**Letter of Intent, and Hardship if Denied, for the Variance of Use Application**

ADD: PCD file # VA266

12260 Smith Rd, Peyton, CO 80831

ADDRESS:
12260 SMITH ROAD
DESCRIPTION:
FALCON RANCHES
LOT 7 BLOCK 1 SUB 1
EL PASO COUNTY, CO

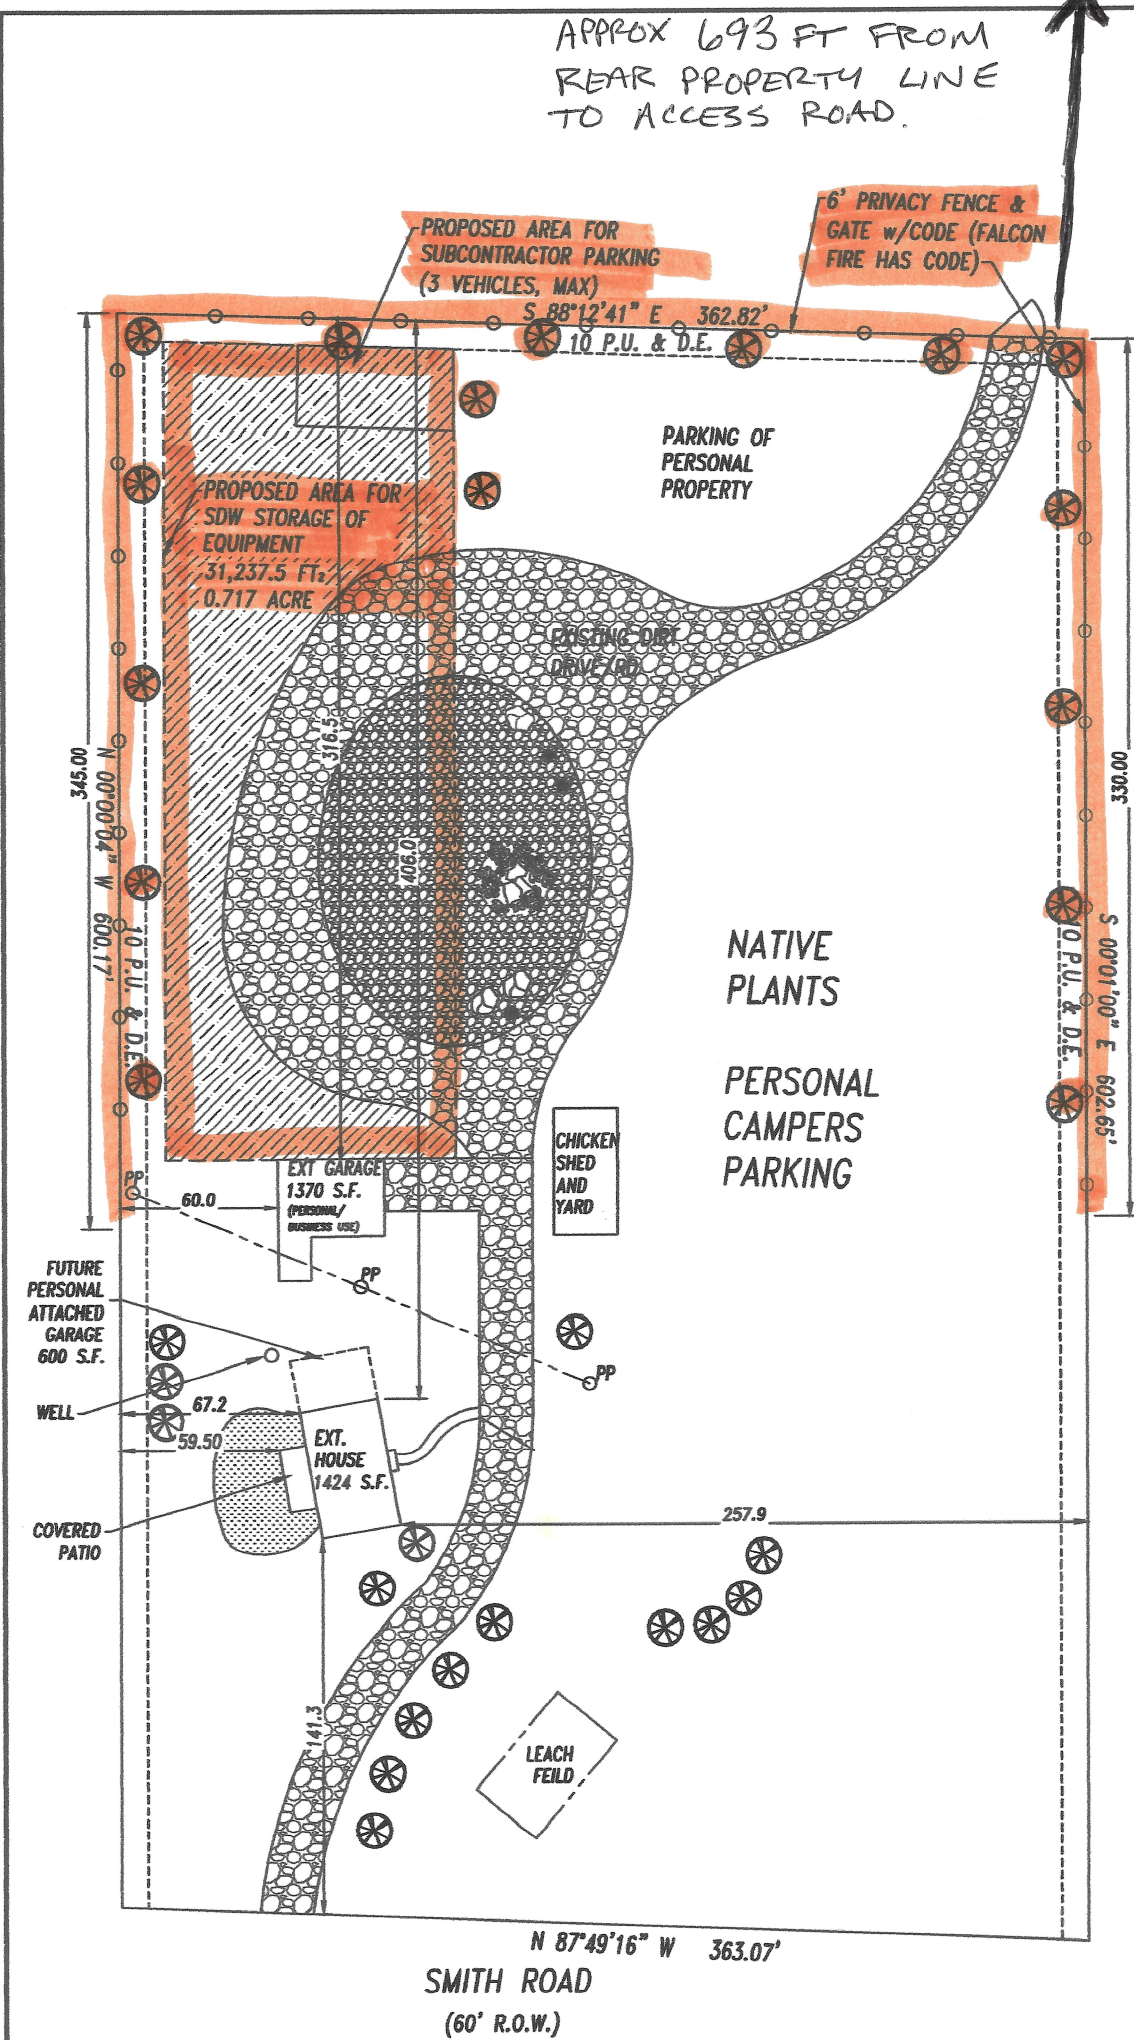
Please add information to include:  
-Hours of operation  
-Number of employees  
-Number of parking  
-Number of vehicles  
-Specific methods and details of screening and landscaping

Land disturbances (clearing, grading, stockpiles, etc) over 1 ac will require an Erosion and Stormwater Quality Control Permit (ESQCP) and Permanent Control Measure (PCM). Verify the area of new disturbances/development and if it is over an acre an ESQCP will be needed. Based on the described 0.7 ac area designated, it appears to be under 1 ac, but please clarify any new development/land disturbance areas specifically.
